From: Amanda Scholes on behalf of Planning.Responses
Sent: 28 March 2018 08:34
To: Planning Scanning
Subject: FW: Planning Consultation on LY/28/17/PL Crossbush Farm Shop Site

[REDACTED]
Sent: 26 March 2018 17:40
To: 'Ian Hayward'
Cc: Anita Gardner [REDACTED] 'Chris Rendle'; 'Alice Rendle'
Subject: RE: Planning Consultation on LY/28/17/PL Crossbush Farm Shop Site

From: Ian Hayward [REDACTED]
Sent: 26 March 2018 14:49

Proposed Site Plan and Location Plan
Existing and Proposed Floor Plan and Elevations

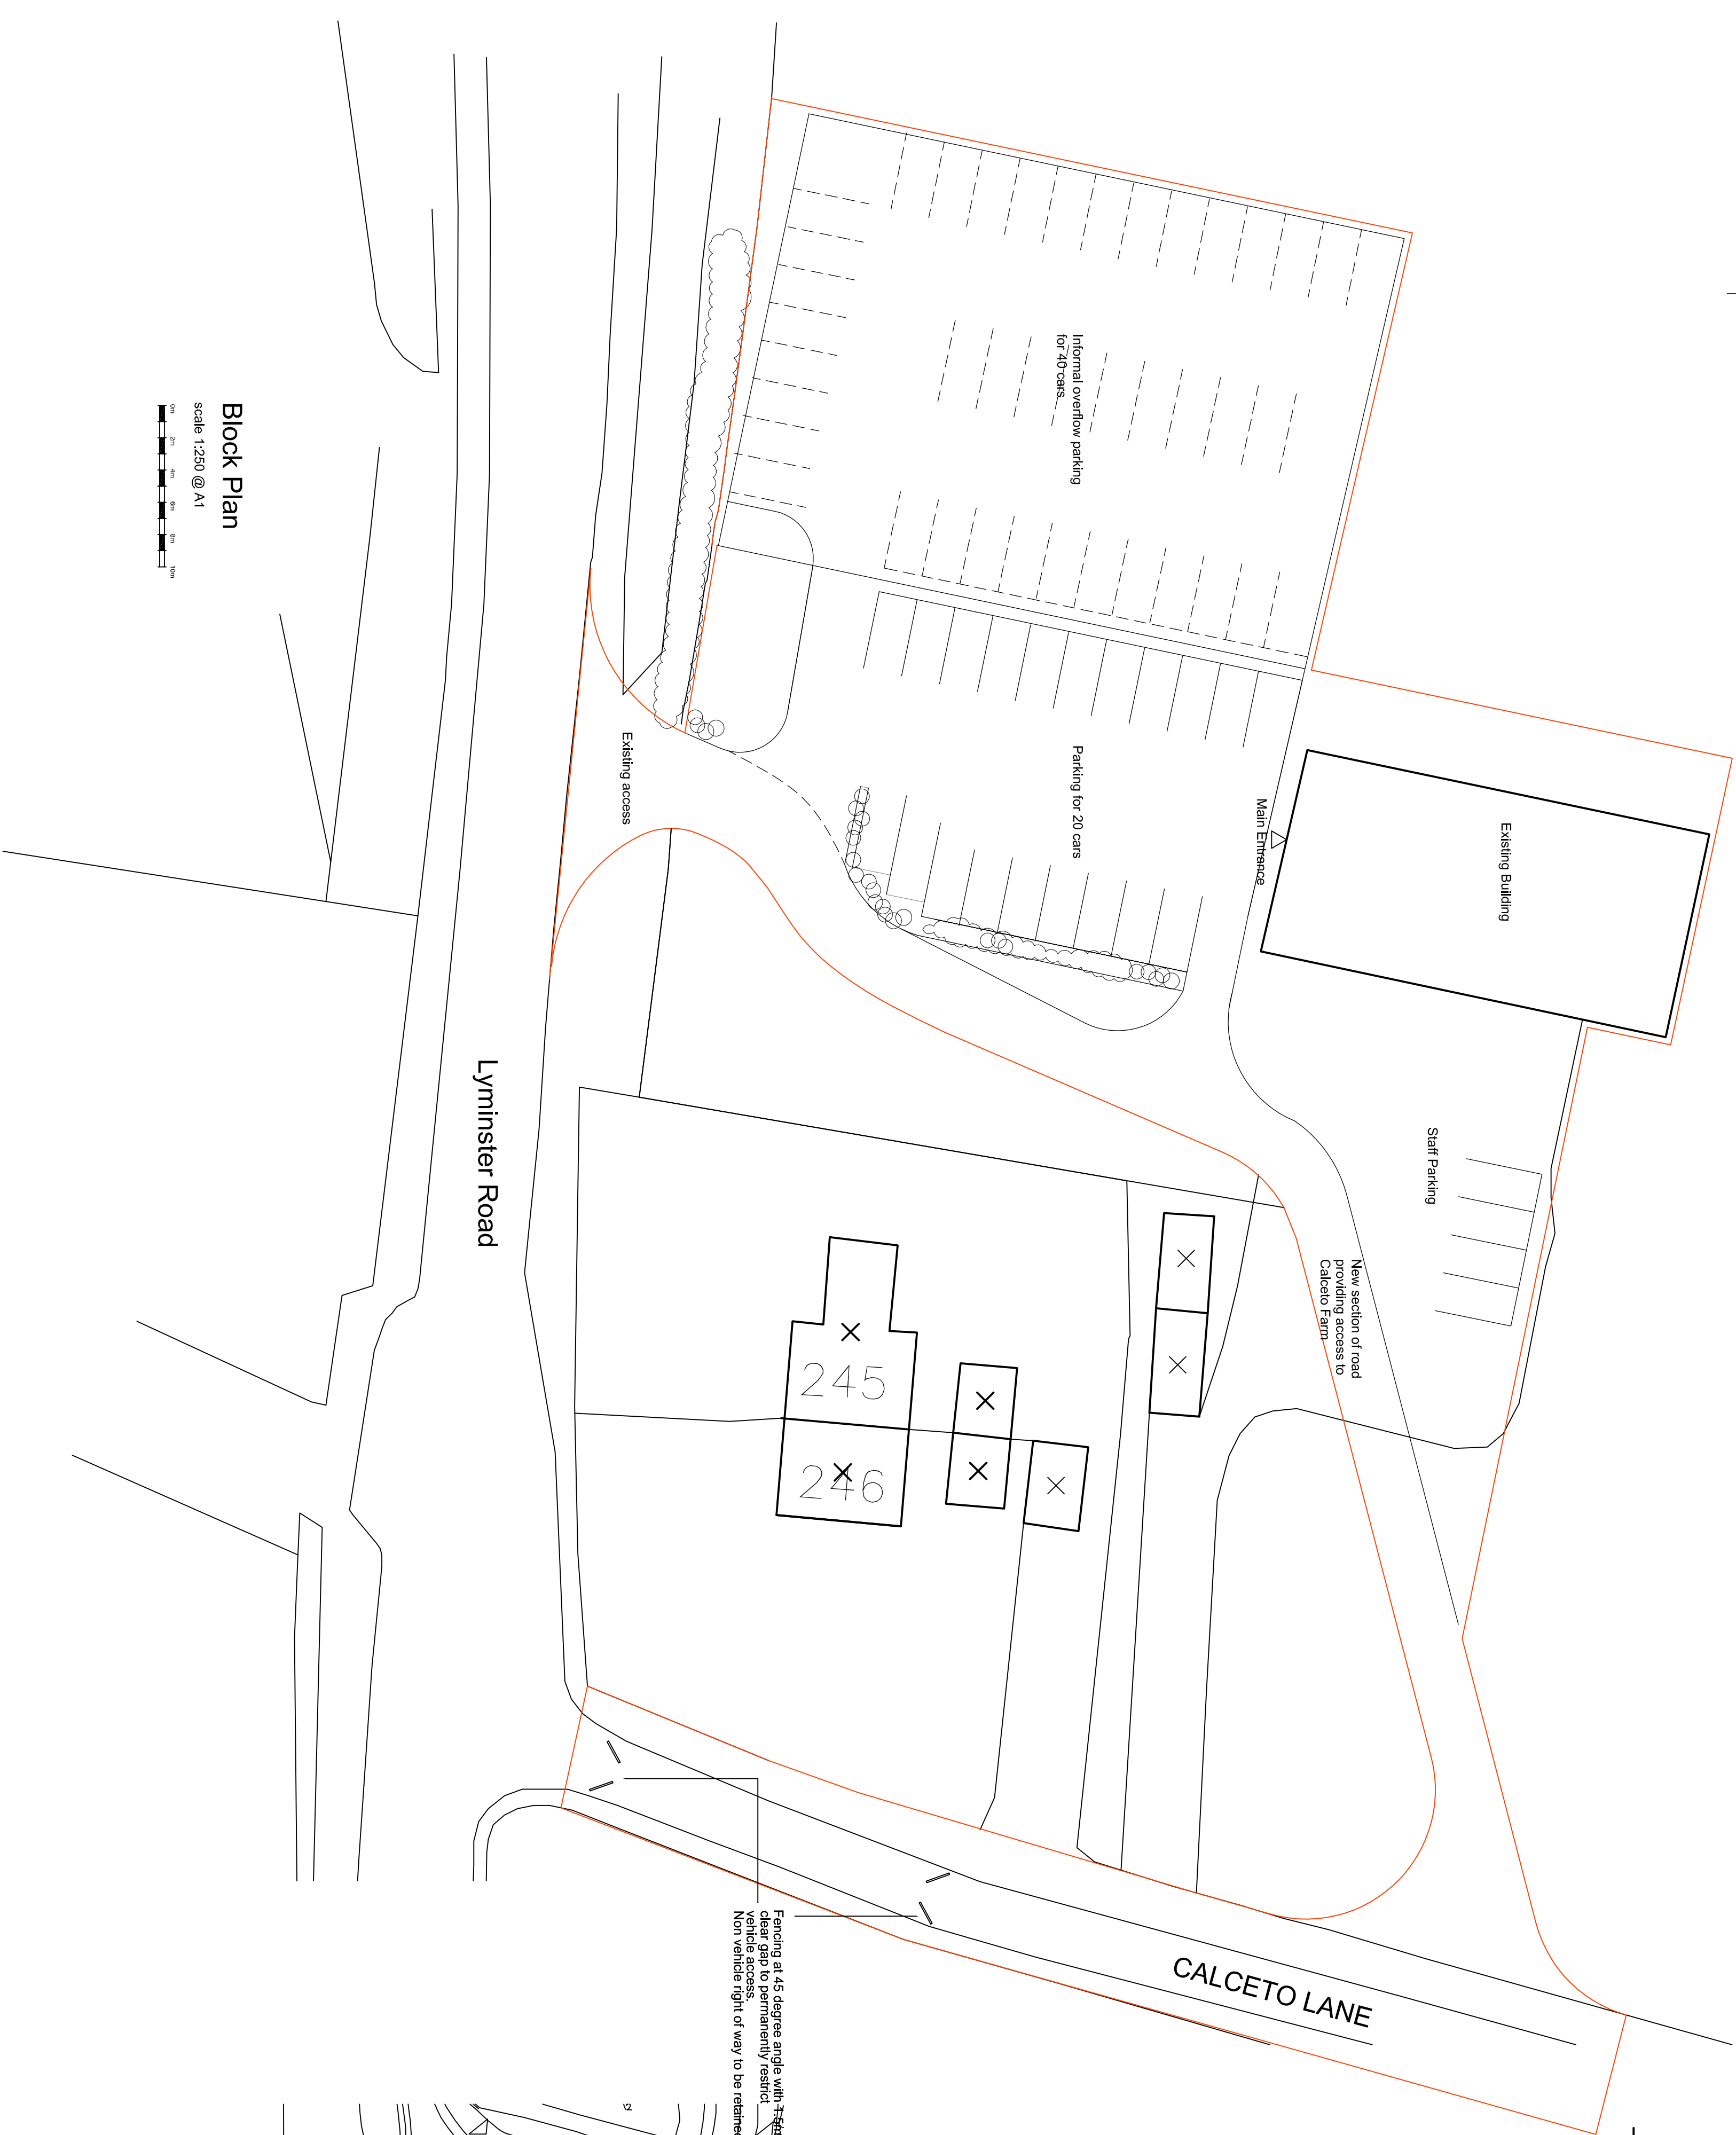
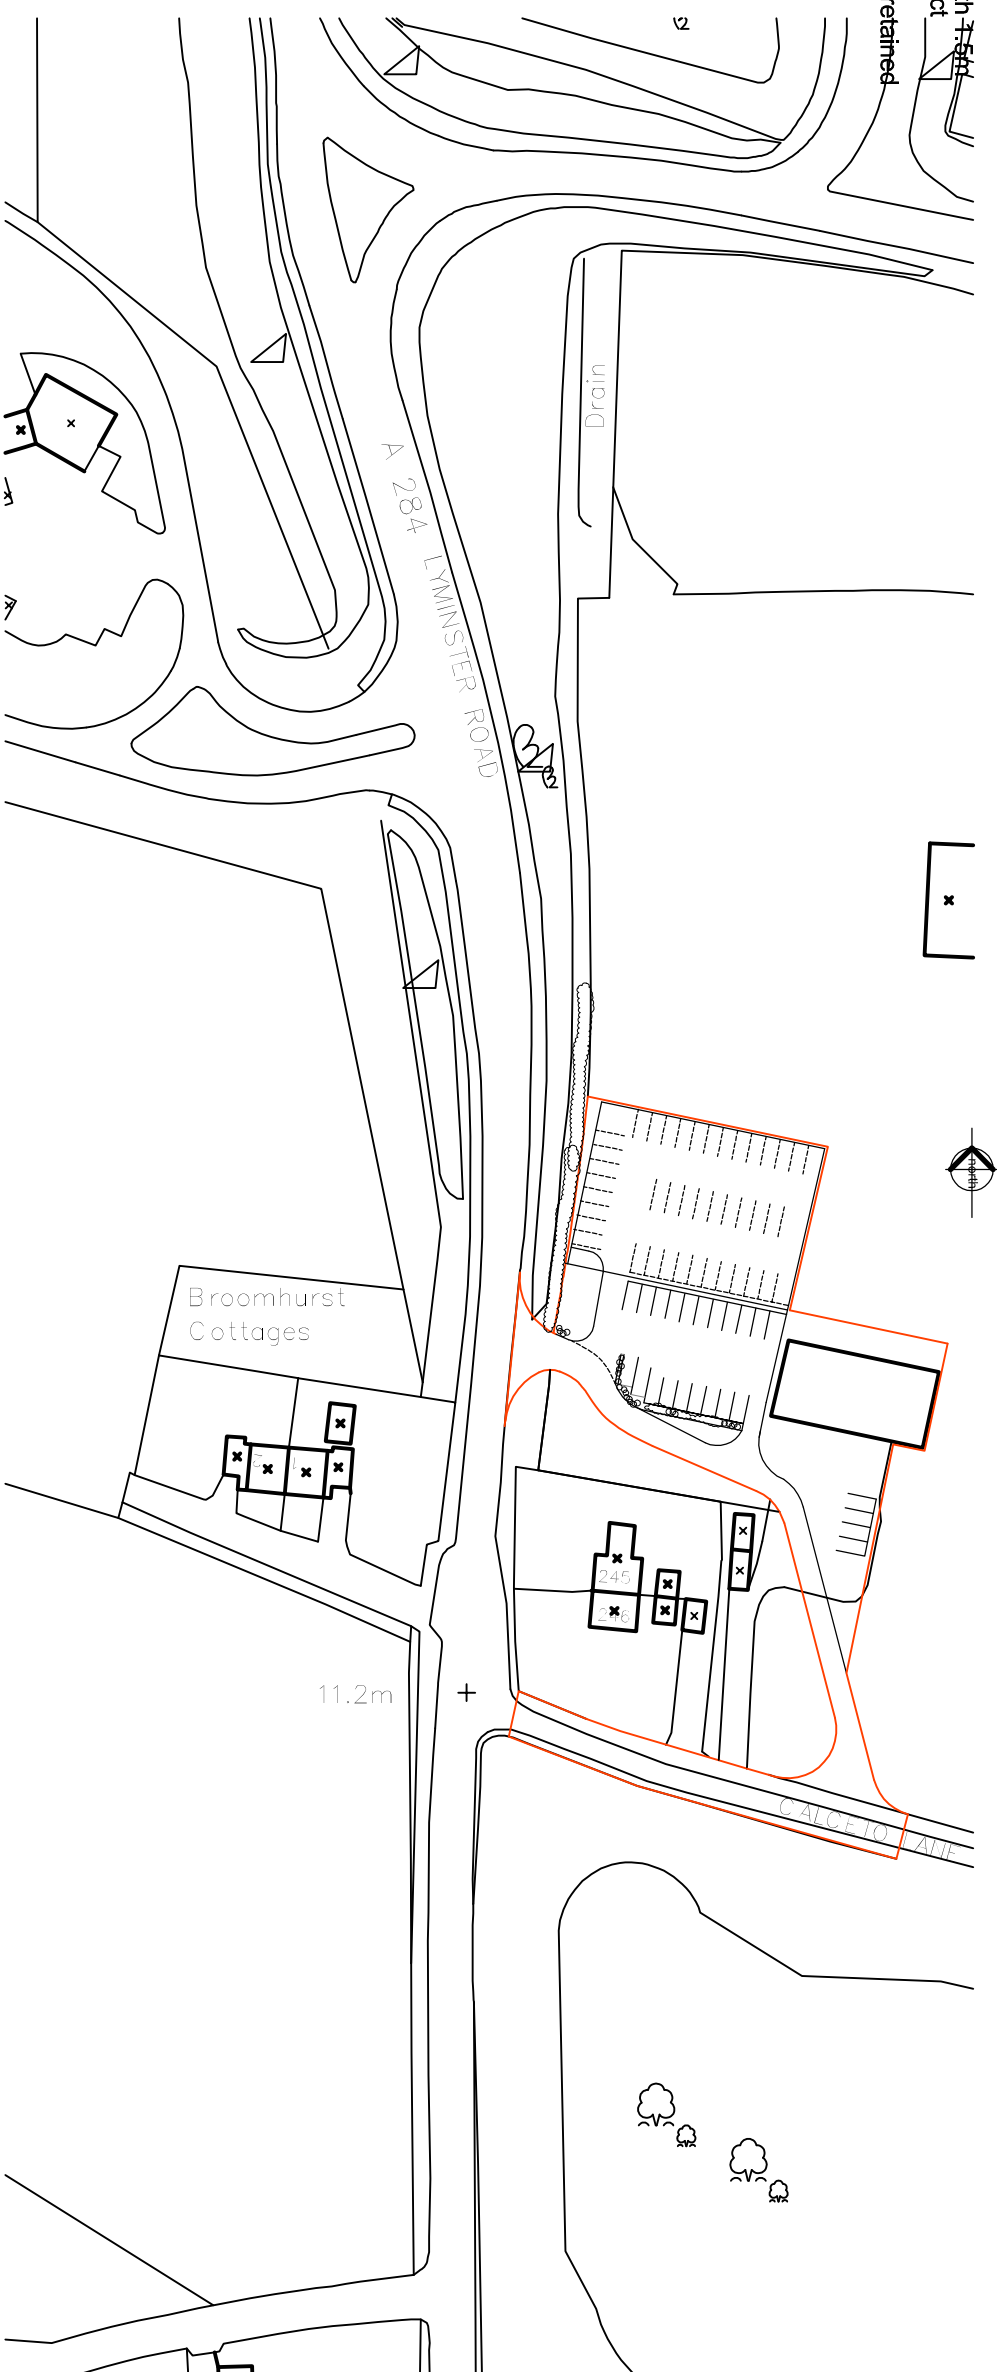
The prohibition of vehicular movements to/from the site via Calceto Lane onto Lyminster Road was a key consideration in allowing the previous change of use application at the site (LY/14/11). I note in your comments below you accept that these closure works will be included as part of this application. We would need to see that annotated and demonstrated on a site plan and it included within the red edge as was the case with LY/14/11.

Our previously quoted parking standards are 'maximum standards' and the sites accessibility by means other than the private motor car are a consideration when assessing parking demand of a development. Essentially these are a worst case scenario, and as such I would not have any issue with an informal overflow car parking provision being used to make up any shortfall in parking demand. We would need to see this area indicated within the red edge so it can be secured via planning condition.

I am arranging with the architect to amend our submitted drawing to include the angled (45degree) fencing that will be installed to prevent vehicular use of Calceto Lane, and also to have the red edge extended to incorporate the amendment into this application. As soon as this is available, I will forward on to both yourself and Anita.

I am additionally arranging for the architect to incorporate the informal overflow parking area into our drawing, including it within the red edge, together with the Calceto Lane Closure fencing as mentioned above.
